Aero Heating - Metal Shop

**CITY OF PORTLAND, MAINE
DEVELOPMENT REVIEW APPLICATION
PLANNING DEPARTMENT PROCESSING FORM
Planning Department Copy**

Aero Ventilating & Heating – Revised Site Plan

DESIGN BY:	JRS
DRAWN BY:	PLS
CHECKED BY:	318
DATE:	8-30-00
SCALE:	1" = 20'
FIELD NO.:	306A
PROJ. NO.:	00179
DRAWING:	00179

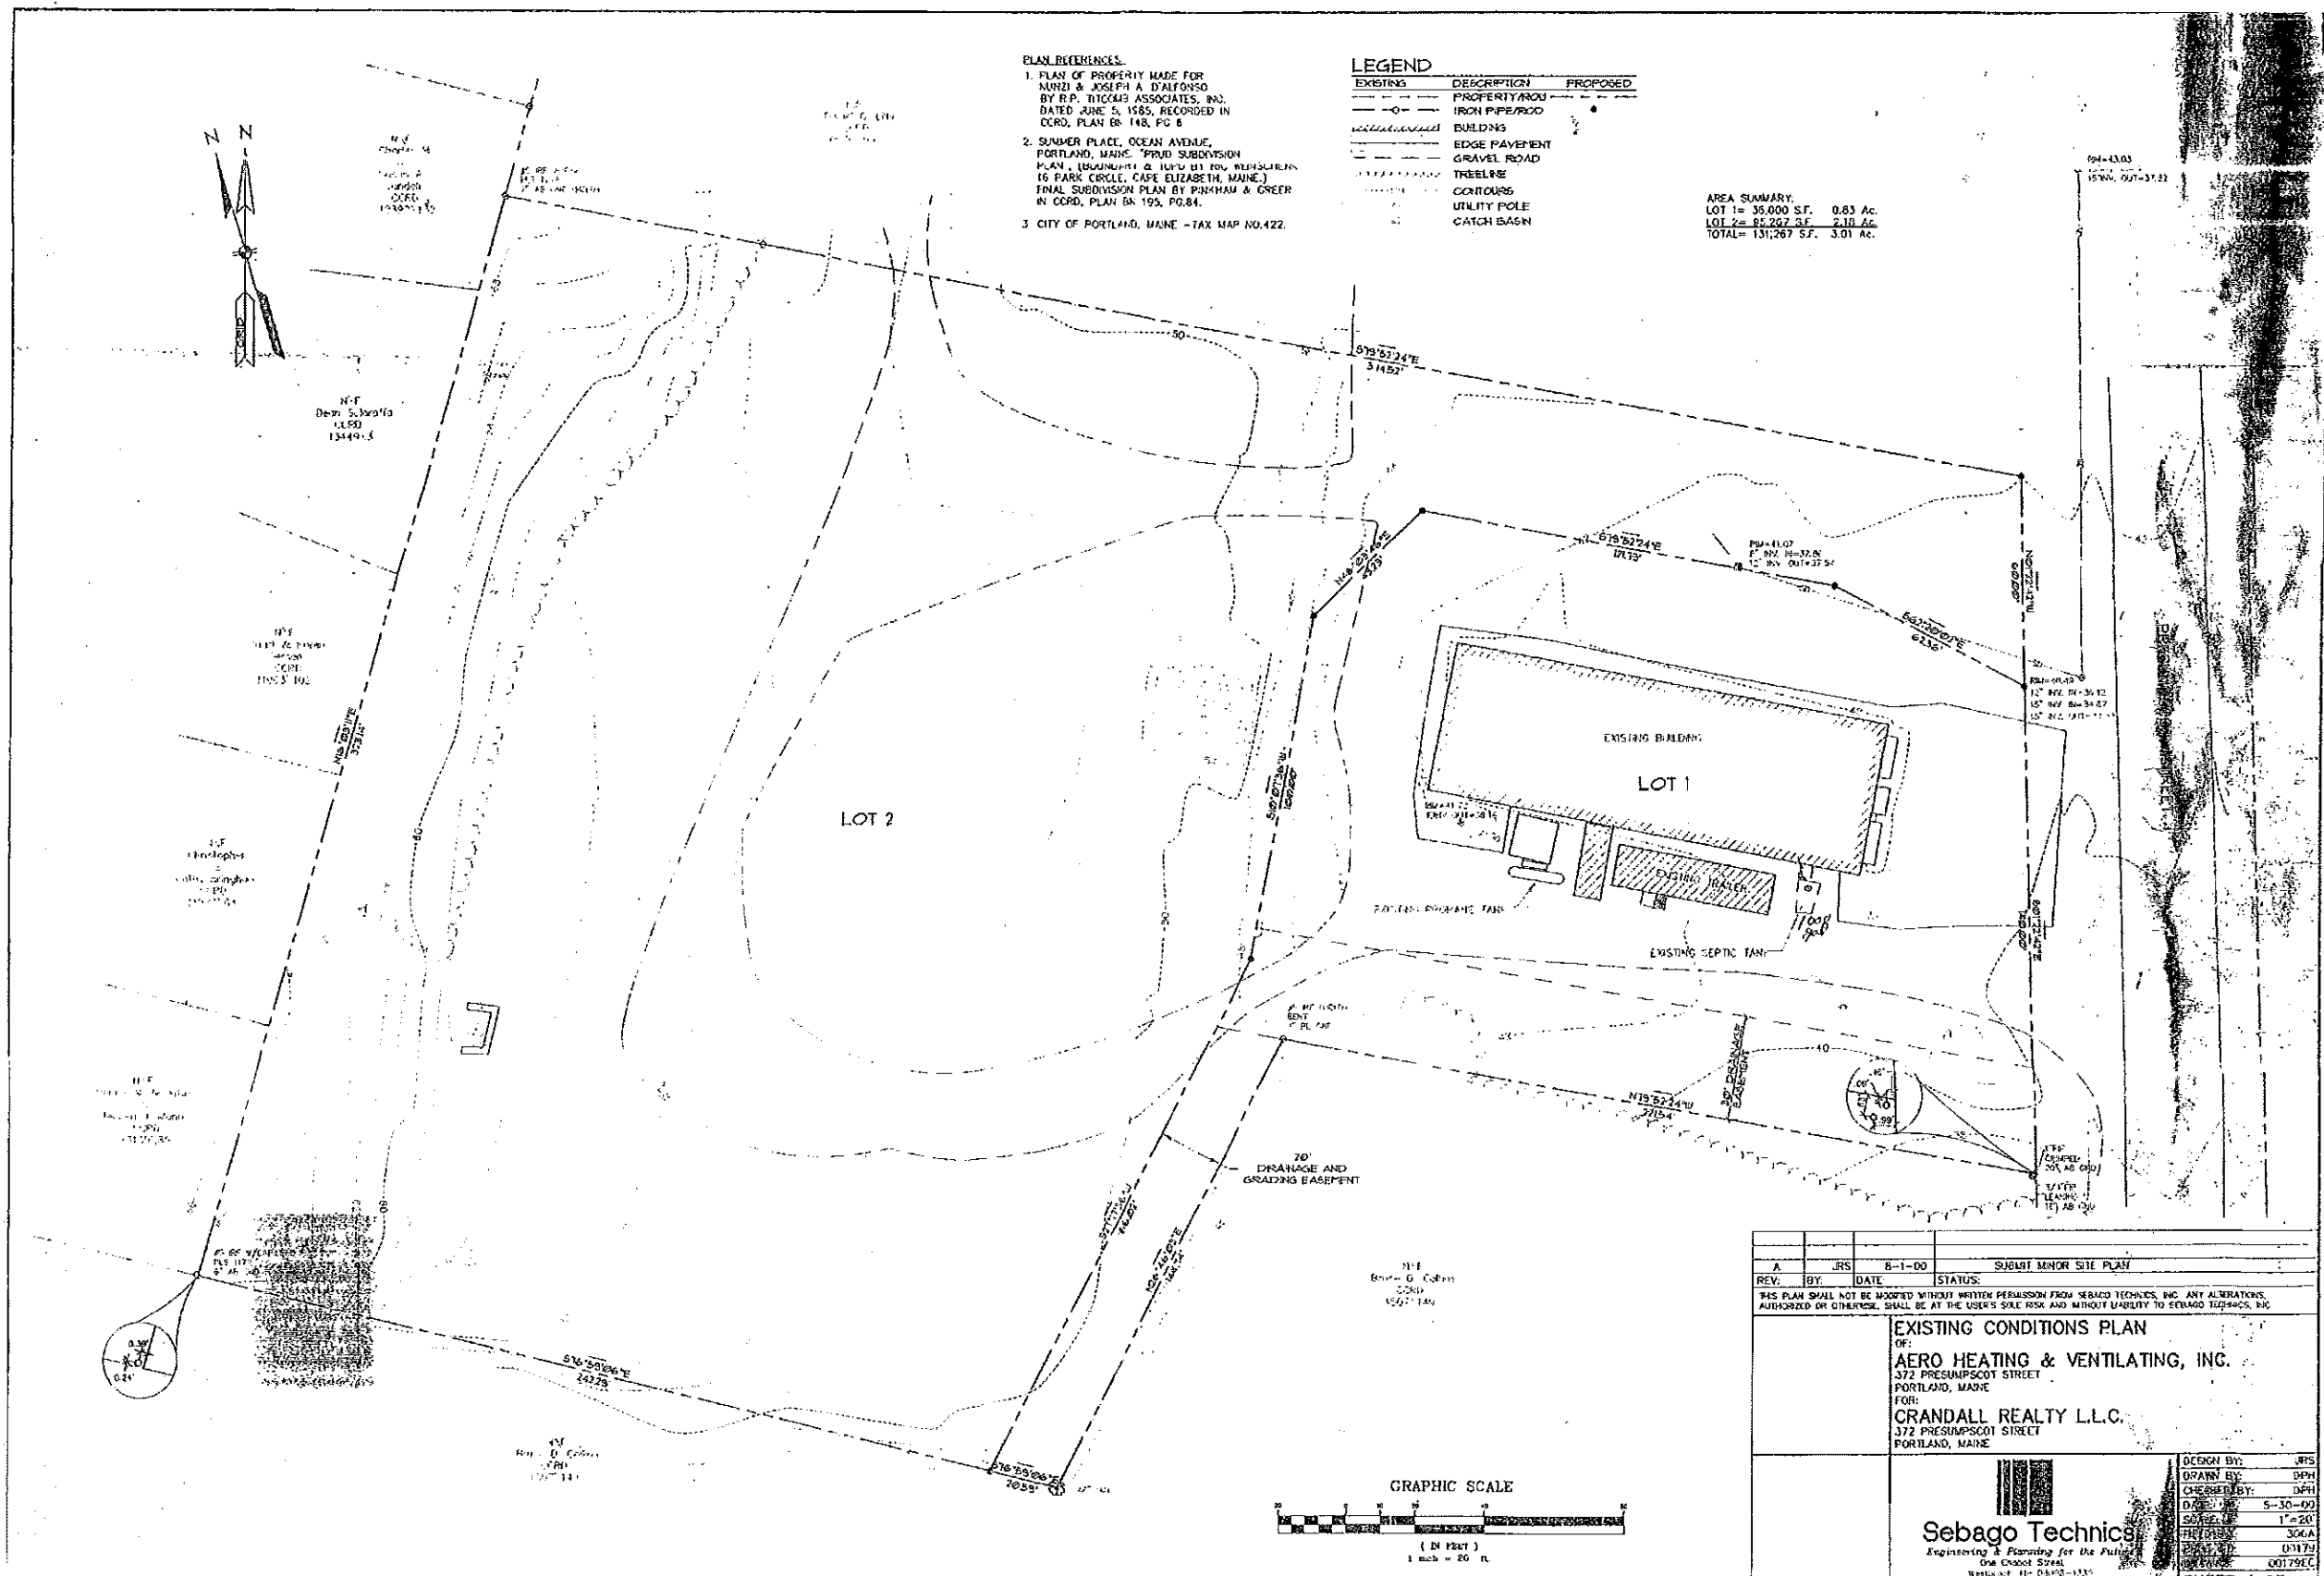
1. Cape Code bituminous curbing has been added along the entire northern edge of the access driveway which abuts the Lilly property. This will direct flow into Catch Basin #1 and keep any chance of flows off the abutter's property.
2. The level lip spreader has been deleted and a new drain manhole will be connected into the existing Presumpscot Street drain system to accept the detention pond discharge. This is done at the request of Public Works. The spillway will be entirely ripped and direct runoff for storms greater than the 25-year size to the existing ditch line.
3. All storm drain pipes within the City's right-of-way will be an HDPE-ADS Pro-link Ultra Soil Tight, or approved equal.

4. All riprap will be 6" riprap per the detail sheet. The site plan note has been changed to 6" riprap.
5. An HHE-200 form was submitted showing a typical cross-section of the proposed septic system. A note was added to the site plan referencing the HHE-200 form and the contractor's responsibility to build in accordance with that document.

1. We have revised the pond's discharge to enter directly into the City's storm drain at the request of Anthony Lombardo, P.E. of Public Works. This should alleviate any impact on the ditch or abutting properties. Only storm events in excess of 5.5 inches in 24 hours will create additional flows to that ditch line. Overall, we will be reducing peak rates to the downstream areas and ditches by directing our site drainage to the proposed pond and City storm drain.

2. Currently, there is no curbing or delineated entrances along Presumpscot Street in this area. The proposed site plan will provide a 24 foot wide entrance with a 25' and 40' curbed radii. The existing building at 372 Presumpscot Street will still have access on the southerly side of the building with an area to circulate entirely around the building. Crandall Realty has agreed (as previously shown on the Grading Plan) to provide a paved entrance off the access driveway to the north side of the existing building. We will not curb from the proposed paved entrance to the existing lot to the right-of-way property line where the granite curb starts. This should provide both large vehicles to access the building and utilize the new entrance to Presumpscot Street and drainage to remain the same as it does currently. The Lilly property to the north will be unaffected by the new entrance for their circulation will continue to be wide open along their entire frontage. Drainage will be improved by the addition of an inlet behind the proposed curb line to Catch Basin #1. Currently, ponding is a problem in this area and it will be corrected with this site design.

3. No impacts will be created from this site to Mr. Lilly's property to the north. The uphill runoff is collected and diverted by a catch basin system to a detention pond located on the south of the site's property. The access driveway is fully curbed to direct all runoff to Presumpscot Street. The entrance has been designed to further collect surface runoff generated from the Lilly site into the Presumpscot Street drains via an inlet and culvert on the north side of the entrance. Also, a 6" underdrain from the Lilly property tying into an existing catch basin on the proposed site will remain. The drainage impacts documented on the Lilly site are believed to be from uphill drainage patterns originating on Ocean Avenue to the Lilly property line where it enters a private system and drains either under or adjacent to his building. Our drainage patterns do not enter or impact that system. Furthermore, we are reducing our off-site drainage contribution to any portion of the Lilly property.

4. Due to the topography and existing buffer, we do not see any advantage to adding evergreen trees to the buffer along the Summer Place property line. To effectively screen the residences above our site would require tree plantings against the fence lines of the homes at the top of the hill. However, that is not on the Crandall Realty lot and Summer Place already had to establish a vegetative natural buffer to the Crandall property line. The vegetation removed or not existing was required to be supplemented by the Summer Place development. Evidence exists that some of that buffer has been cut to increase their views to the ocean. Therefore, we feel the buffer will provide no benefit to the residences atop the hill from screening the proposed building.
